Re: Homewood Suites
5400 San Antonio Dr. NE
Request for Certificate of Occupancy
Transportation Development Final Inspection
Engineer's/Architect's Stamp dated 4-11-18 (E15D050)
Certification dated 8-28-19

Based upon the information provided in your submittal received 8-28-19, Transportation Development cannot approve the release of Certificate of Occupancy for the above referenced project.

Drawing file: 9-6-19 Transportation Perm CO correction photos / 9-6-19 Transportation 60Temp CO correction photos .pdf

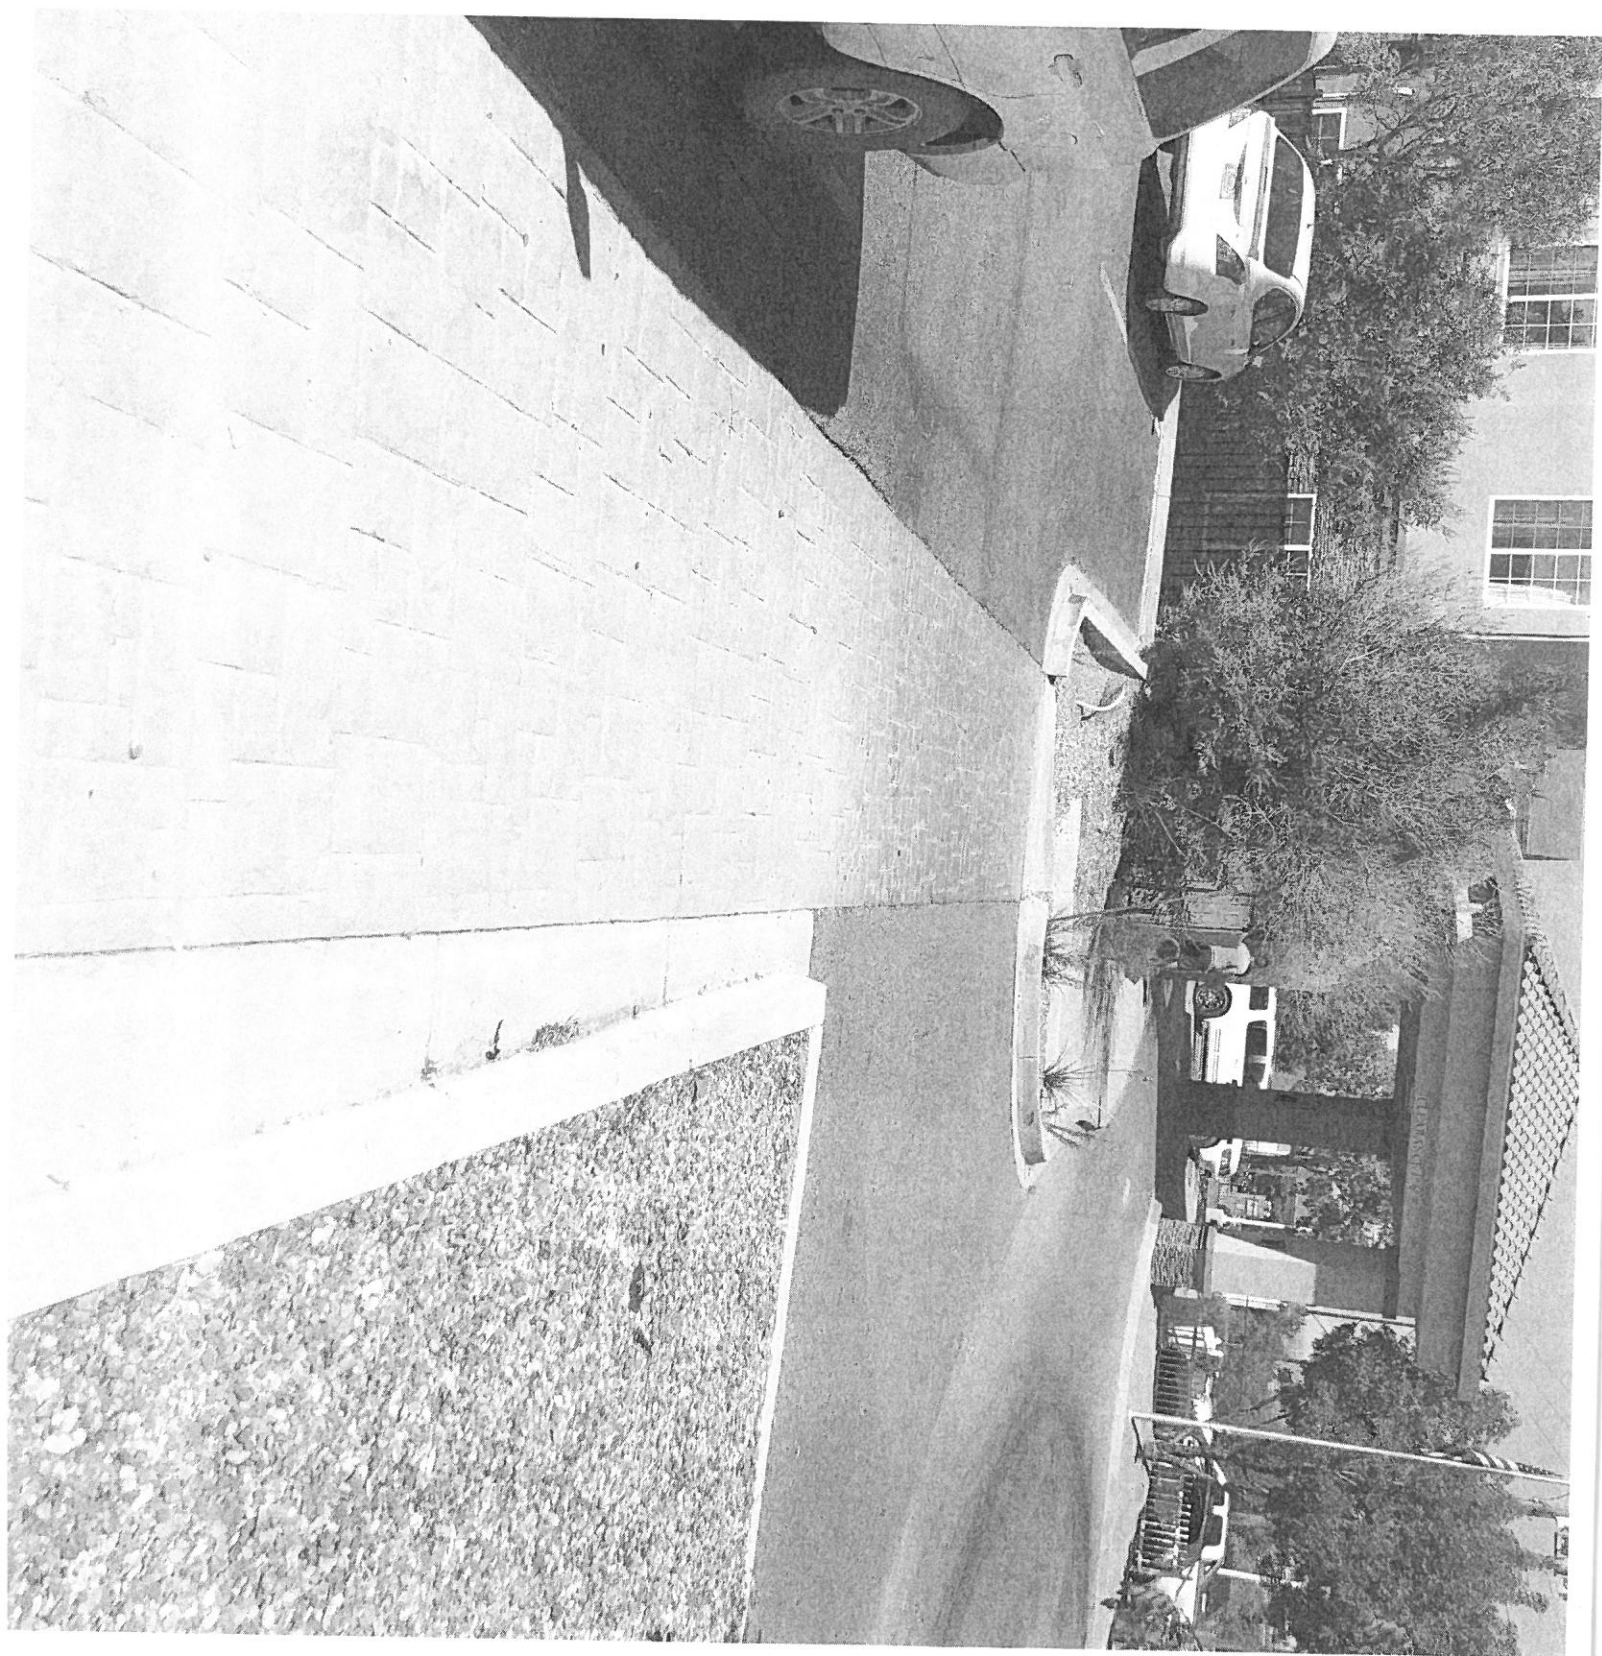
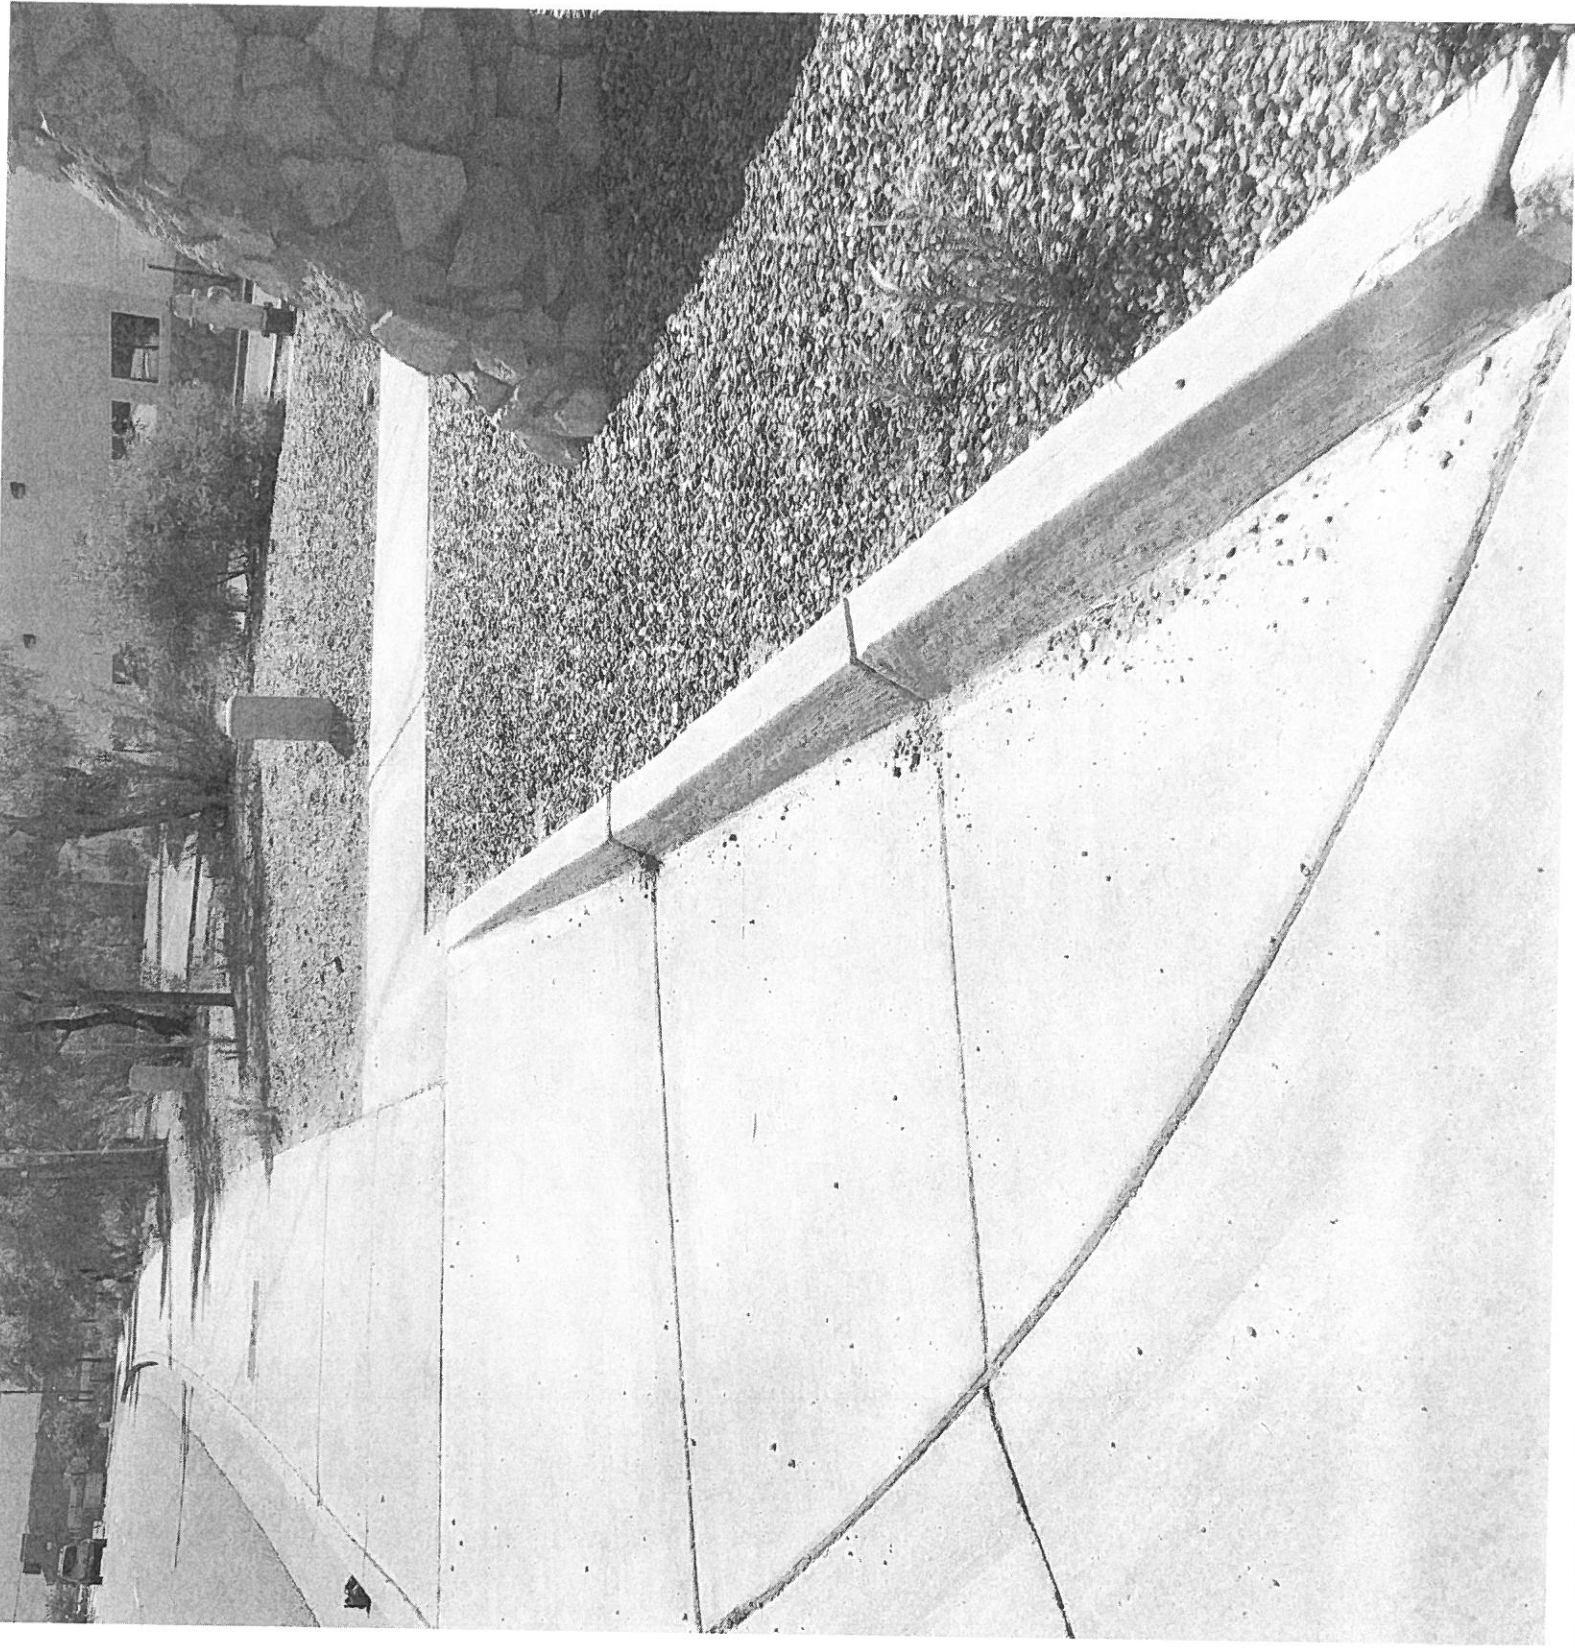
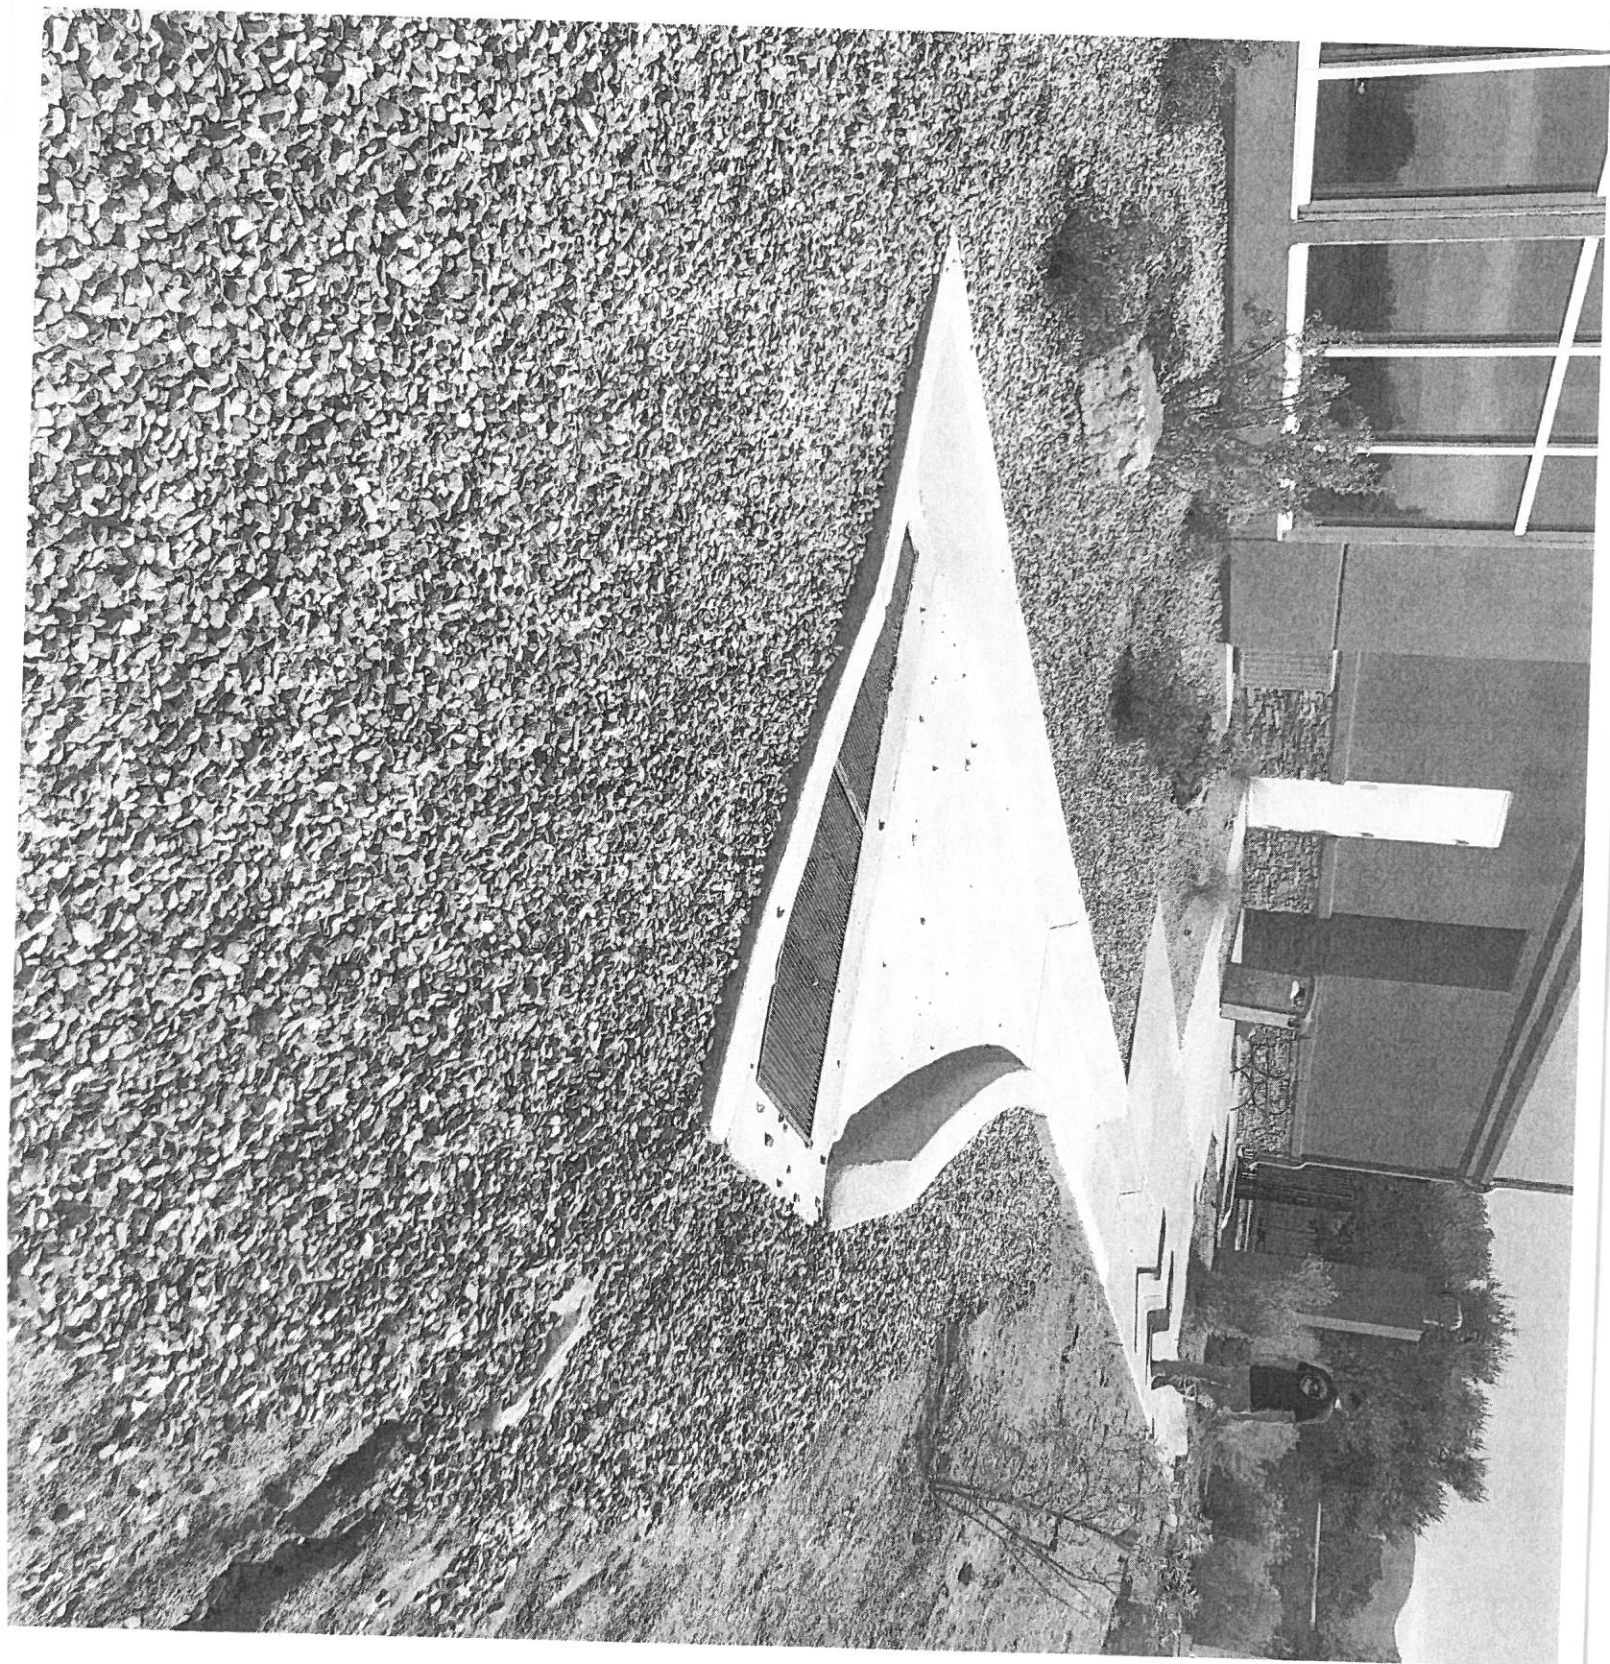
- Add 6ft wide ADA accessible pedestrian pathway from sidewalk to building entrance. Missing ramps and sidewalk. Refer to approved DRB site plan.
- Add missing motorcycle stalls and signs.
- Add missing ADA signs. Stalls located next to Patio.
- Please correct ramp leading to existing building. Ramp has 1" lip not allowing wheelchair access.
- Add sidewalk connecting to path along channel. Refer to approved DRB site Plan.
- Add bollards to parking stall on NW corner. Refer to approved Grading & Drainage Plan. Attach is the section of the Grading Plan indicating the barrier.
- Attached is the DRB Site Plan. Circled in RED are the areas of corrections.
